April 30, 2024

**Re: Playa del Sur Subdivision at 5720 Miami Blvd. NE  
Erosion and Sediment Control Plan  
Engineer's Stamp Date 1/26/24 (H11E075)**

Based upon the information provided in your submittal received on 4/23/2024, the above-referenced ESC Plan cannot be approved for a Grading Permit until the following comments are addressed.

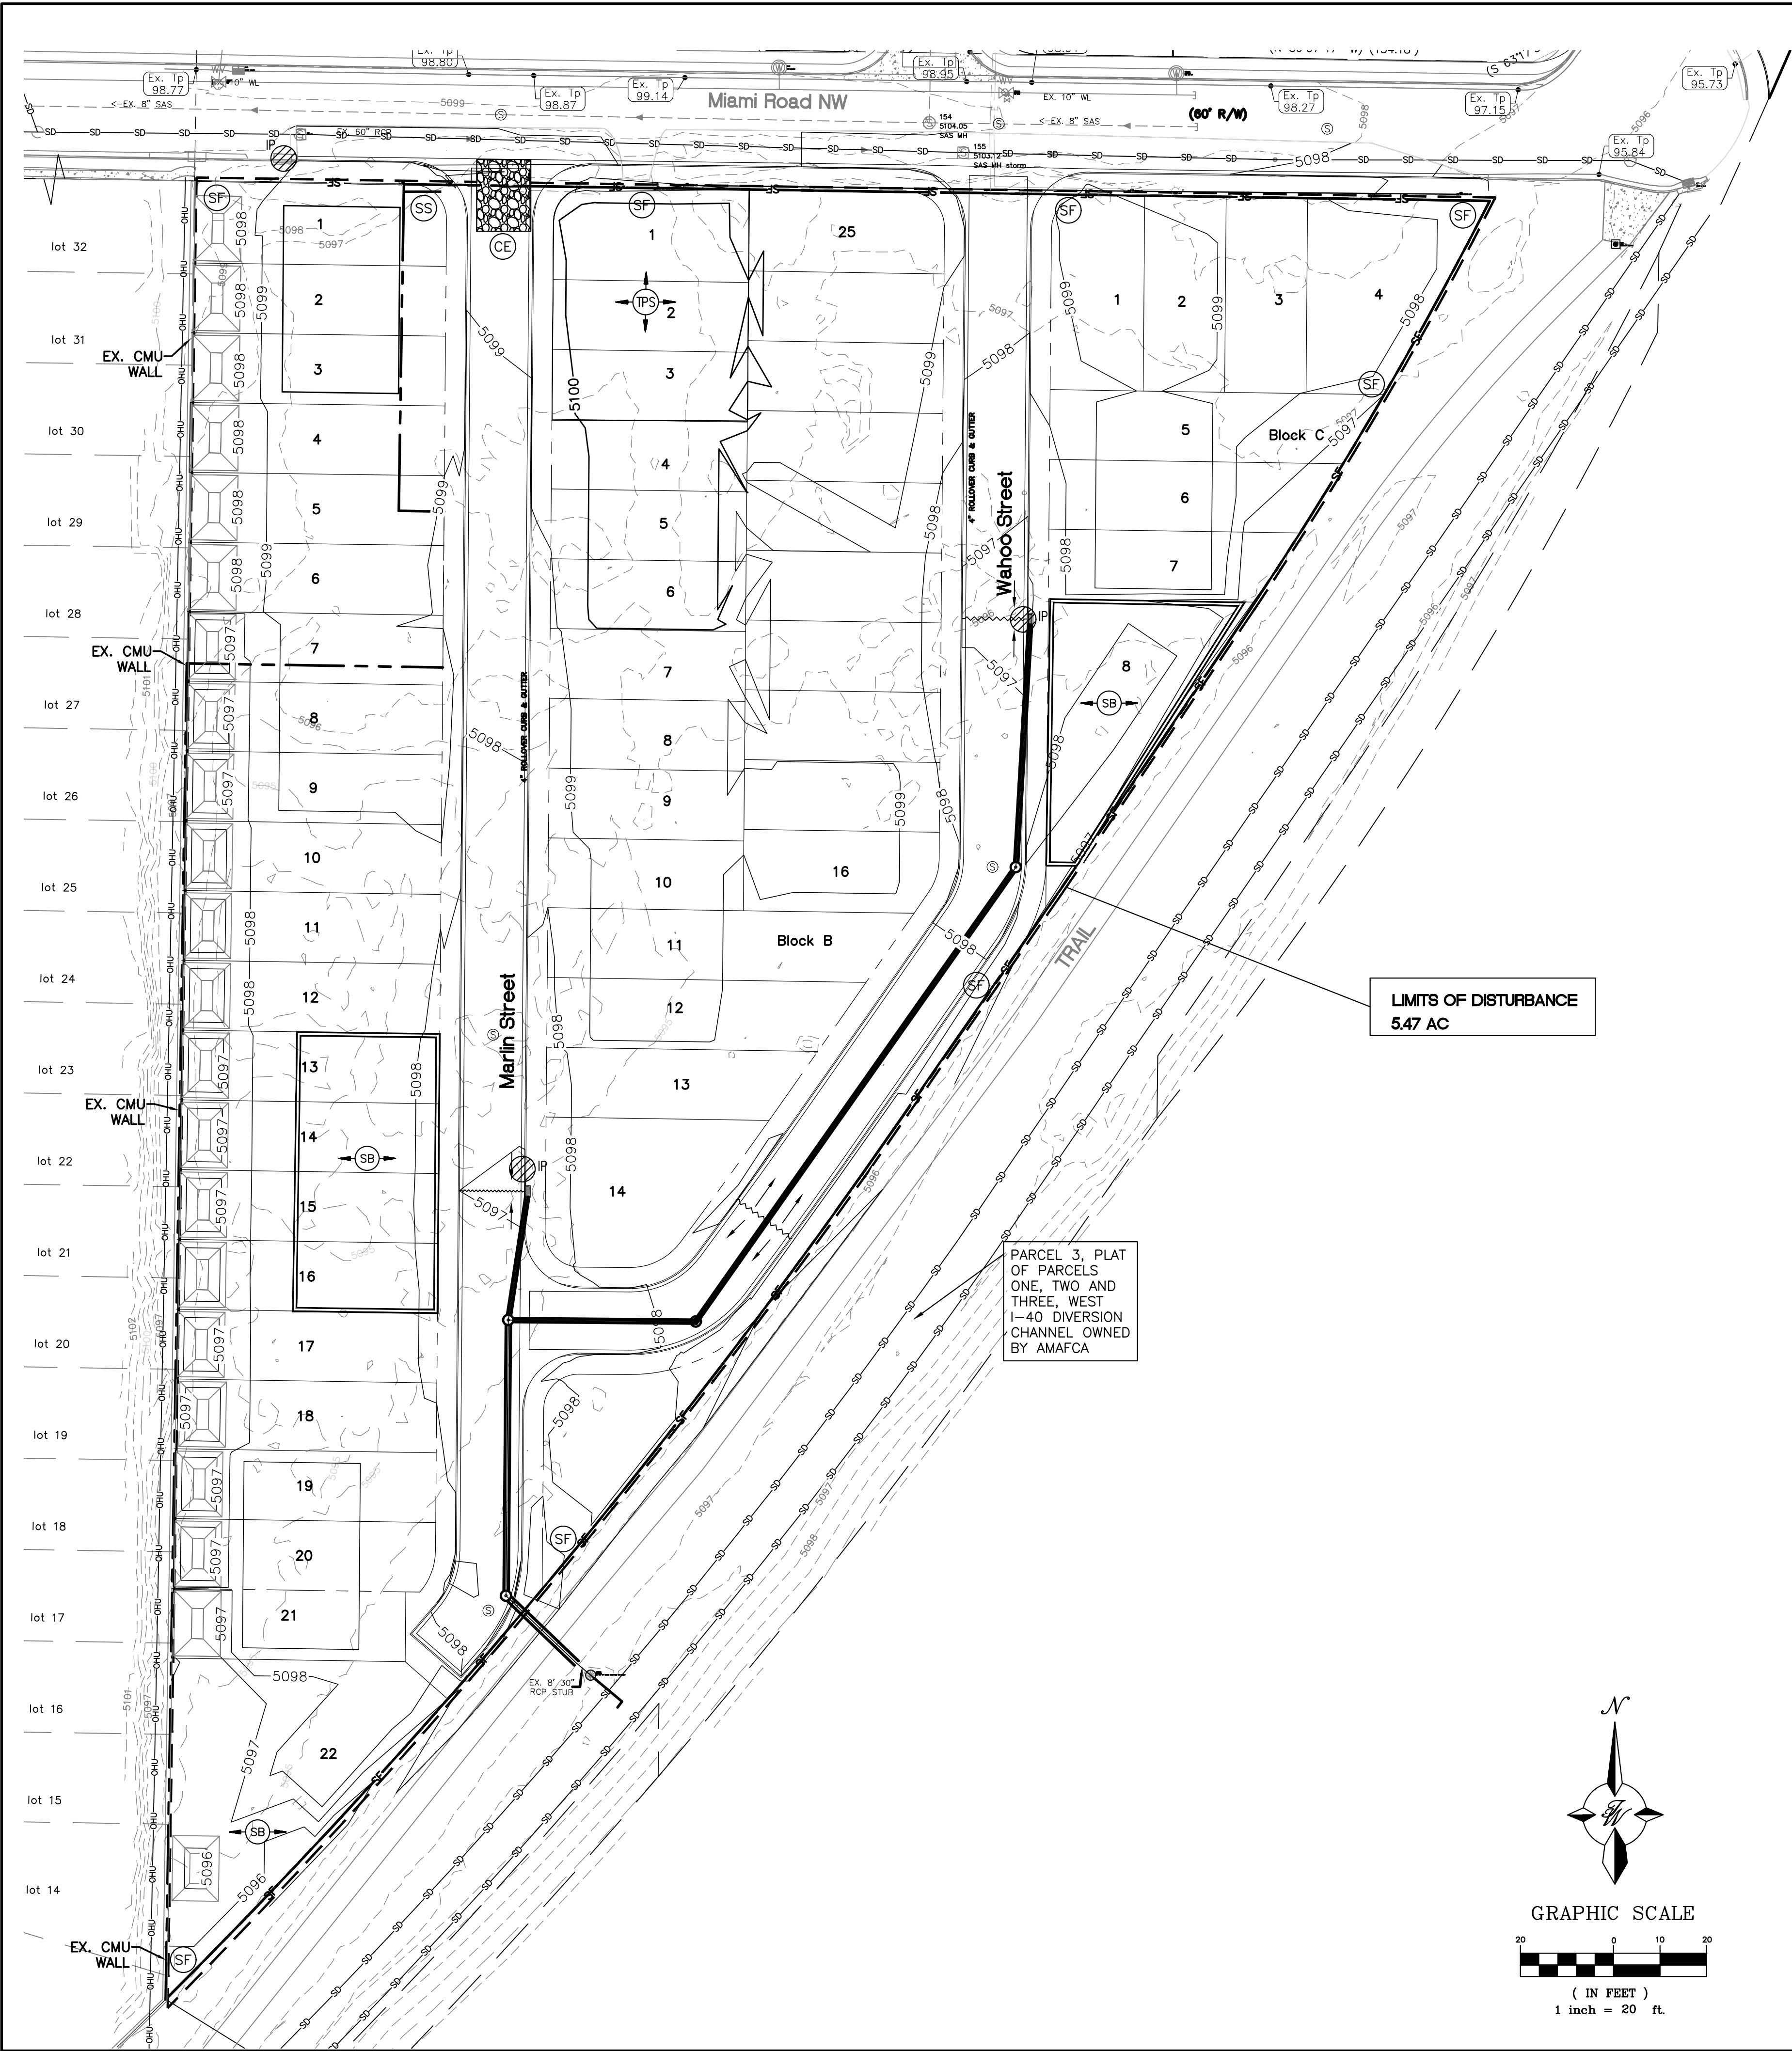
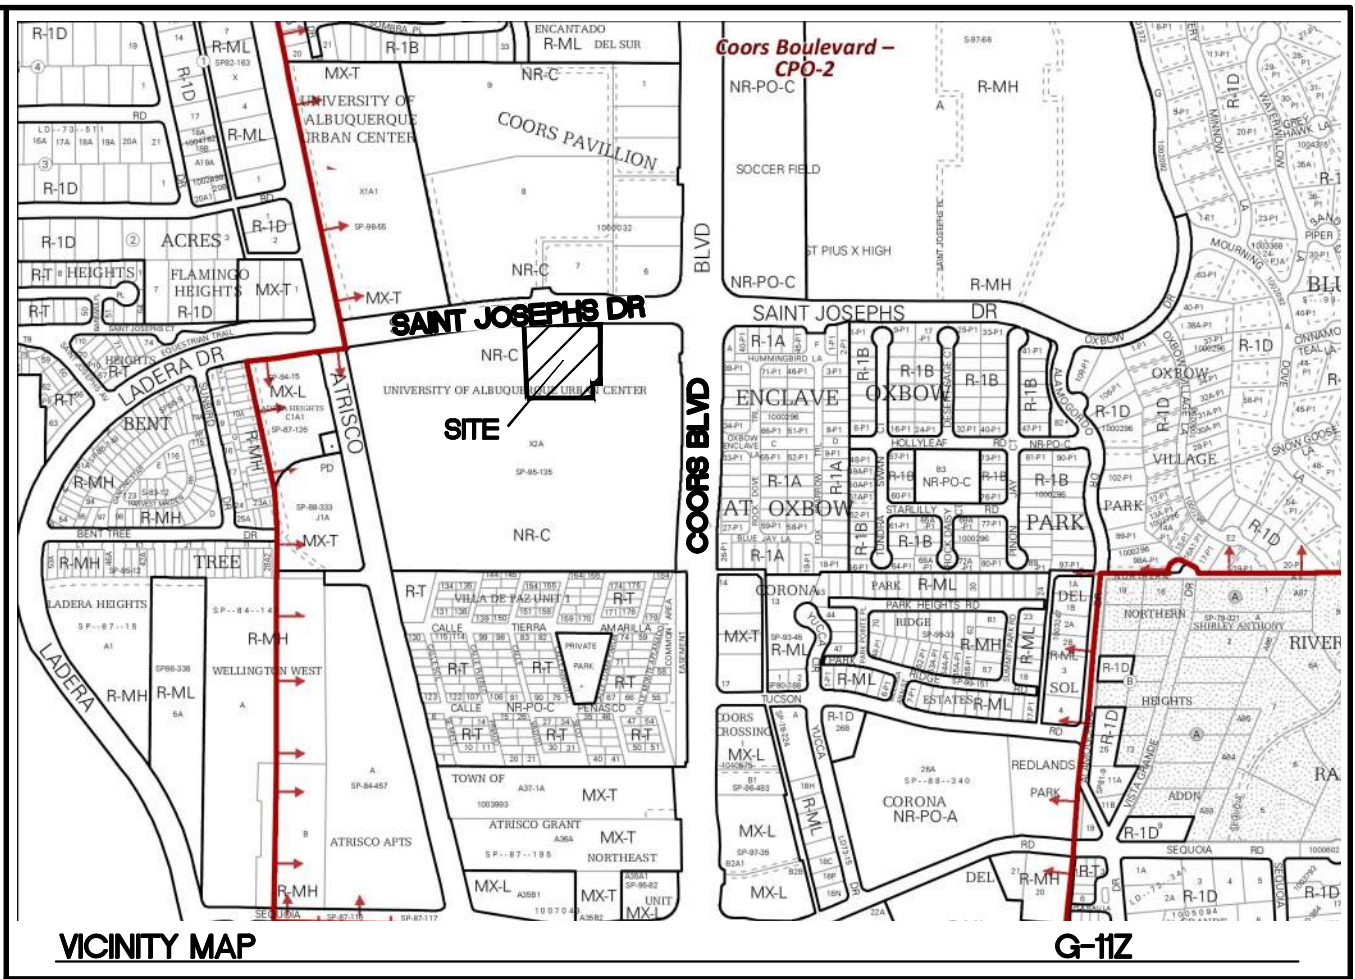
1. You must submit a "SWQ Info n fee" application with every submittal and resubmittal.
2. The vicinity map doesn't show the vicinity of this site. Instead, it shows the Sandia Labs Federal Credit Union Site on Saint Joseph's Dr. Please correct the vicinity map on sheet SW-1.

3. The sequence of construction is missing steps, and the plan is missing Erosion and Sediment Controls (BMPs) to get from infrastructure completion through the development of the individual lots. You cannot begin construction without a clear understanding of how you will get to the termination of CGP coverage. The sequence should include the entire process, beginning with the Commencement of Construction and concluding with the Conditions for Terminating CGP Coverage per CGP 8.2.1. Identify the "completion of the Work Order (WO) construction" and subsequent steps for completion of the development of the lots. Identify when the sediment basins (SB) will be removed. Identify the transfer of any of the lots to new owners if that is part of the anticipated development process.

7. Cutback Swales, or some other form of perimeter control, must be shown on the ESC Plan along the frontage for Building Permit (BP) approval. The BMP should be established by the developer near the end of the grading and construction of the public infrastructure, then it should be maintained during Build Permit by the home builder during construction under Building Permits CGP 2.2.3.
8. Add a note on the ESC Plan stating, "New lot owners must file their NOI 14 days before taking control of any lot(s) transferred to them before development and stabilization is complete."
9. Update the engineer's stamp date each time the plan changes.
